GRADING & EROSION CONTROL PLANS MAYBERRY, COLORADO - TRACT K APARTMENTS

EPC STORMWATER REVIEW COMMENTS
IN ORANGE BOXES WITH BLACK TEXT

V1_Grading & Erosion Control Plan.pdf Markup Summary 11-7-2023

GESC PLANS	
JOB NO.	MC22068
ORG. SUBM. DATE	03/21/2023
DWN.	LAO
CHKD.	CJD
NAME	
EROSION & SEDIMENT CONTROL PLAN - INITIAL	
NO.	8.2

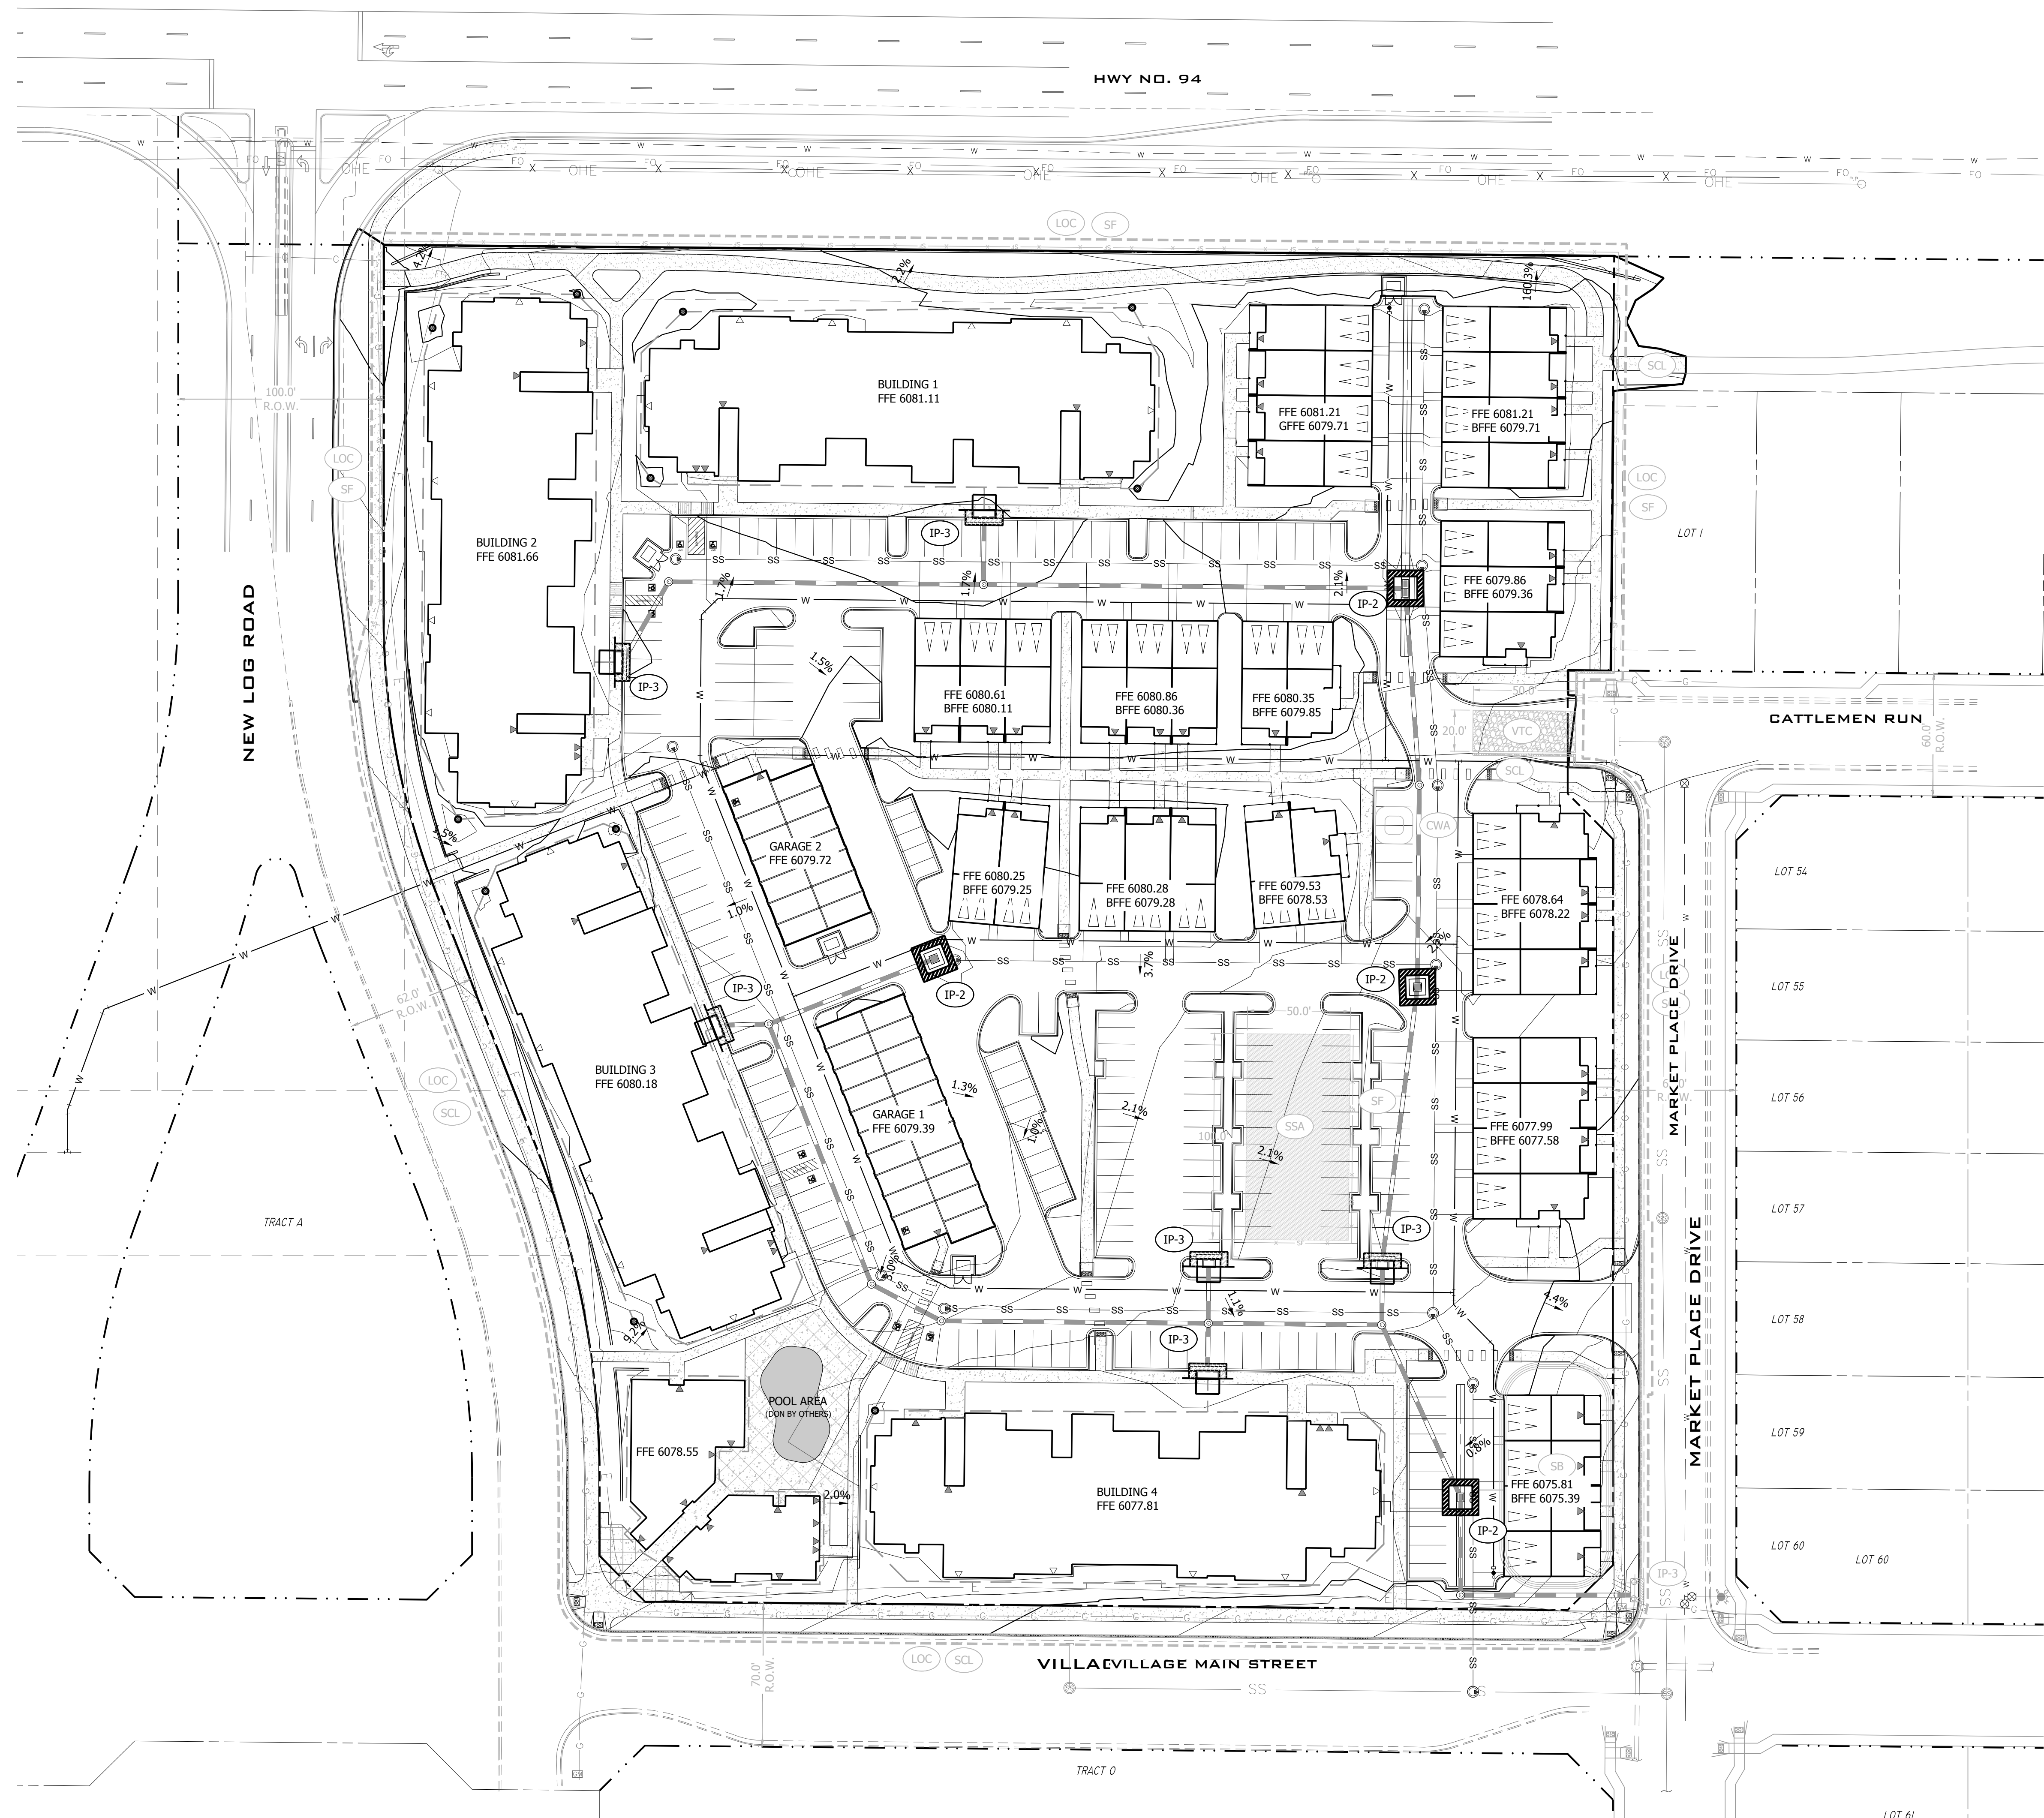
show all existing contours.
show existing stormwater flow direction arrows

show existing drainage
swale contours

Provide details of temporary
sediment basin including
riser pipe diameter and
perforation sizing, number
of rows of holes, required
volume, location of outlet
pipe and spillway, and
tributary area to the
sediment basin

GESC PLANS  
 JOB NO. MC22068  
 ORG. SUBM. DATE 03/21/2023  
 DWN: LAO CHKD: CJJ  
 NAME

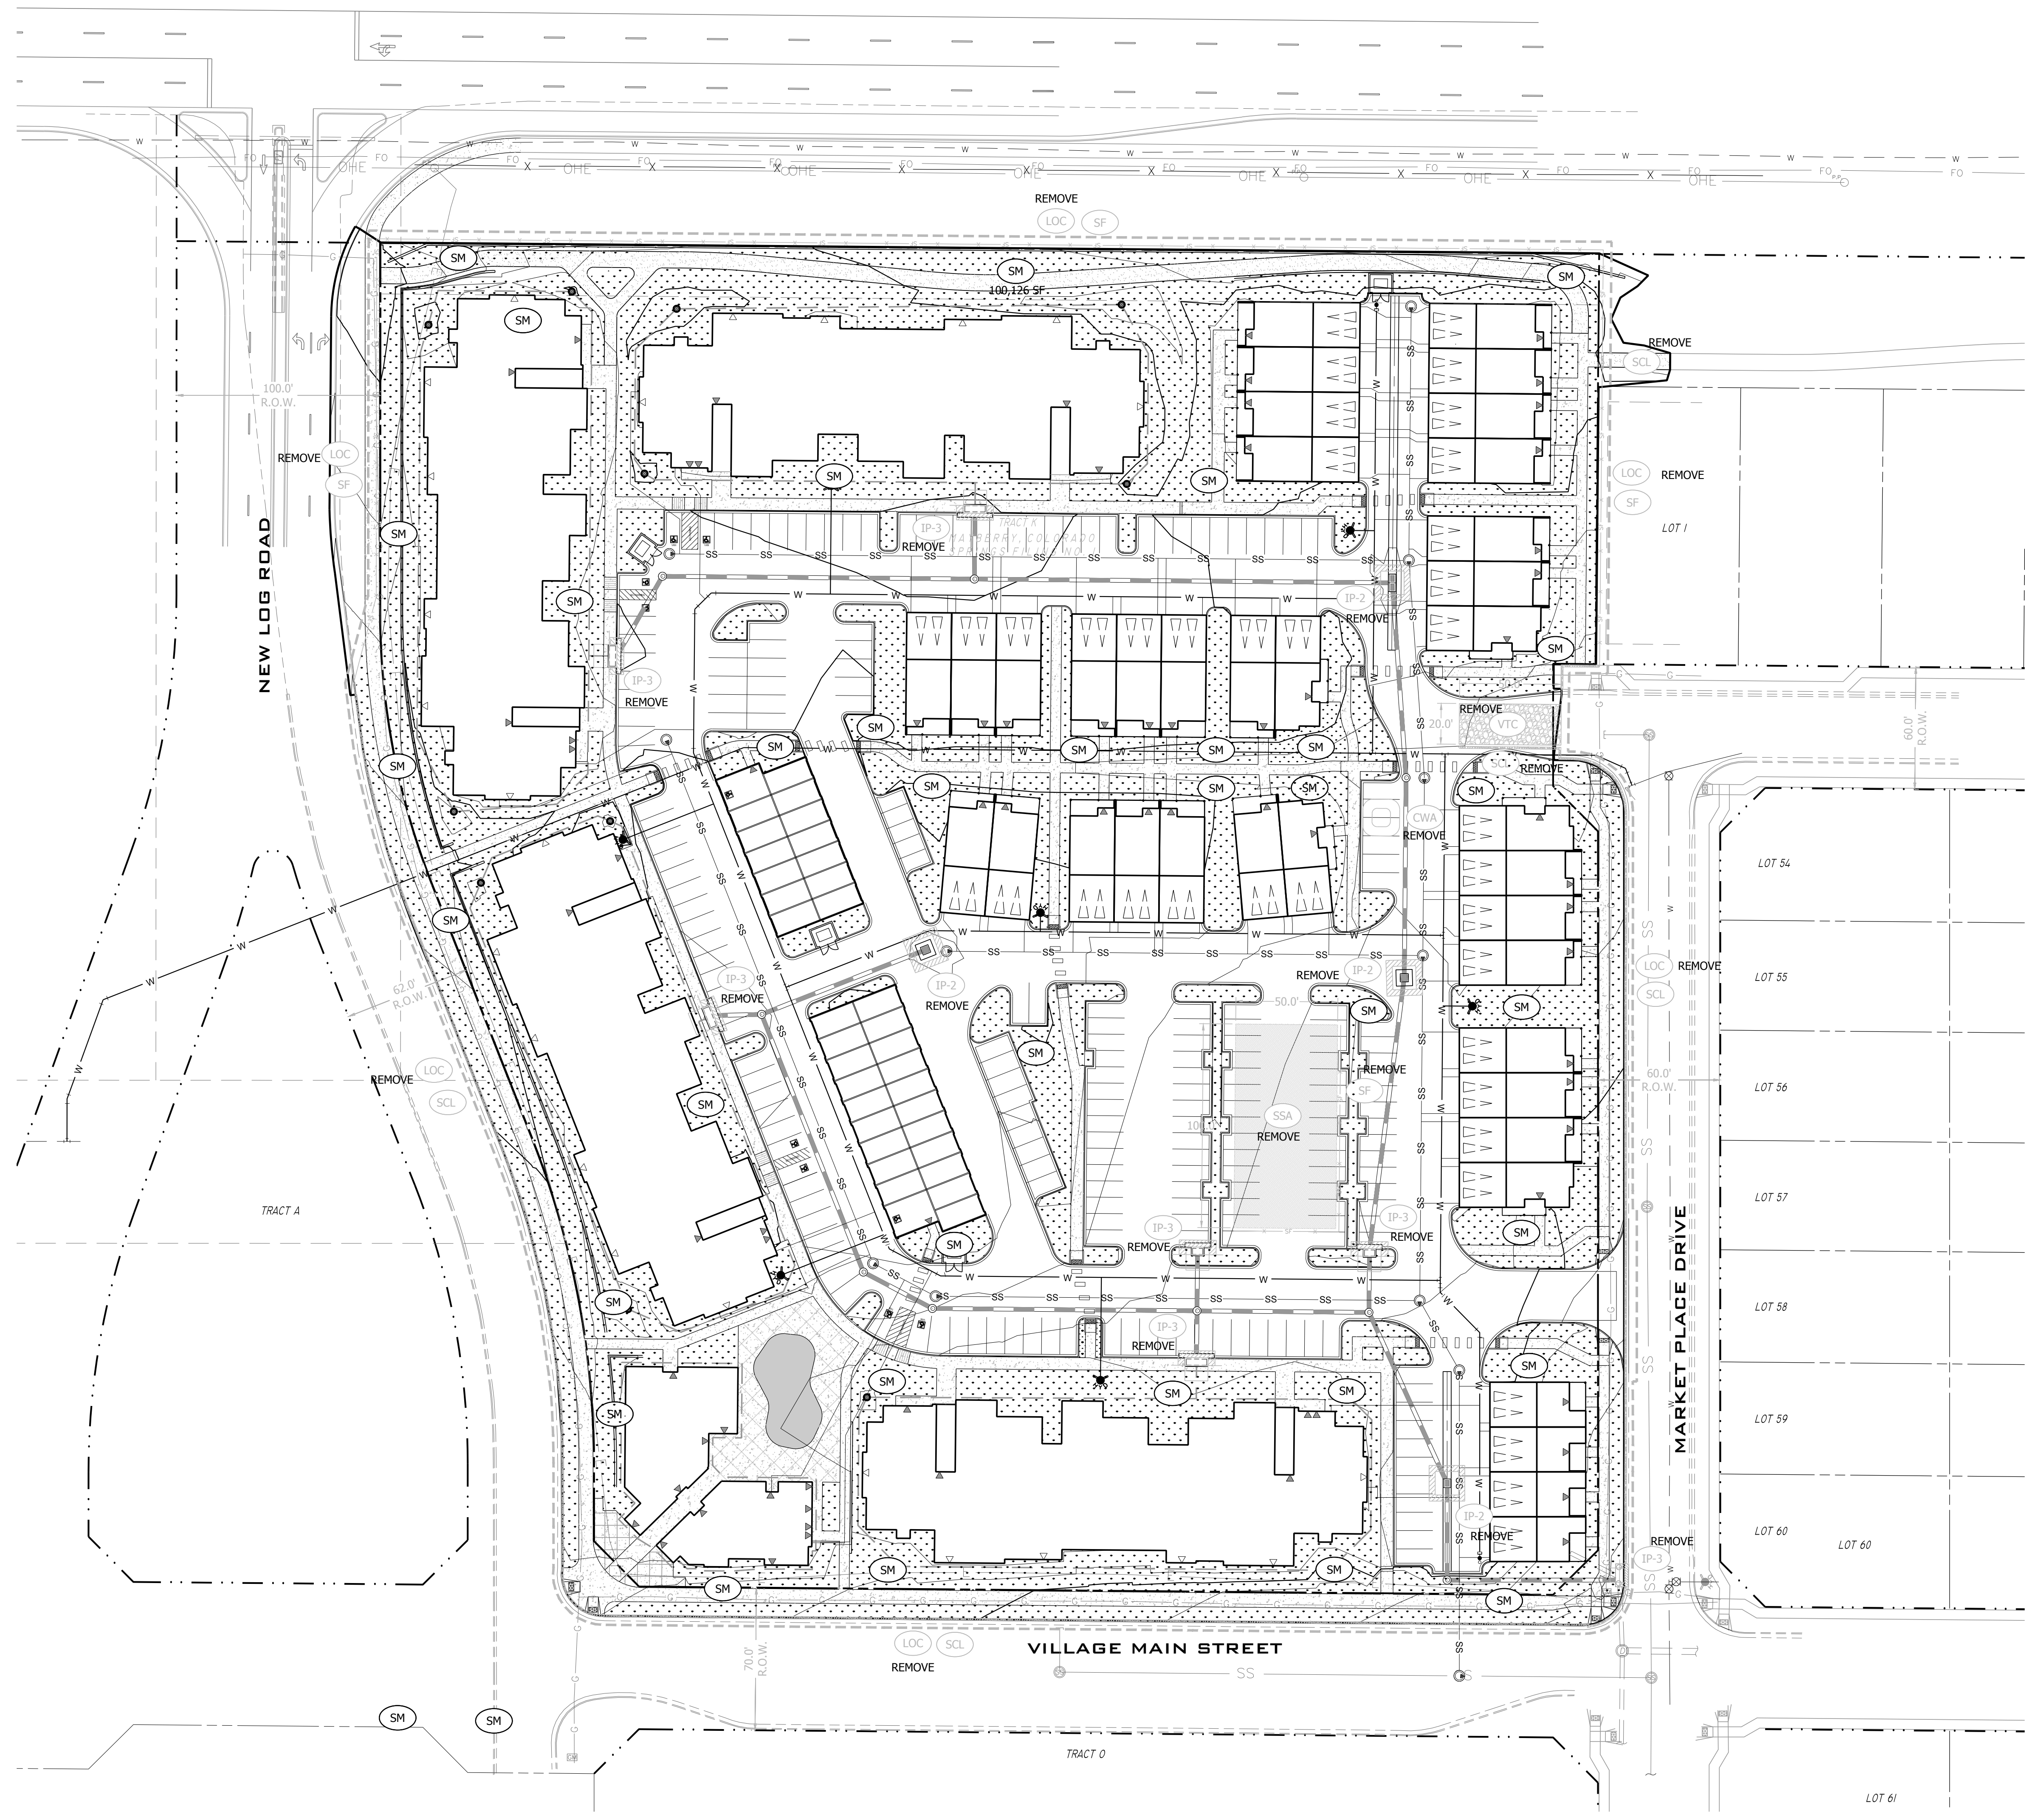
show all existing and proposed contours.
show areas of cut/fill
show existing and proposed stormwater flow direction arrows
Only show buildings, pool, curbs, and asphalt parking lots on final sheet

show existing drainage swale contours

how will stormwater be directed to TSB in interim conditions?
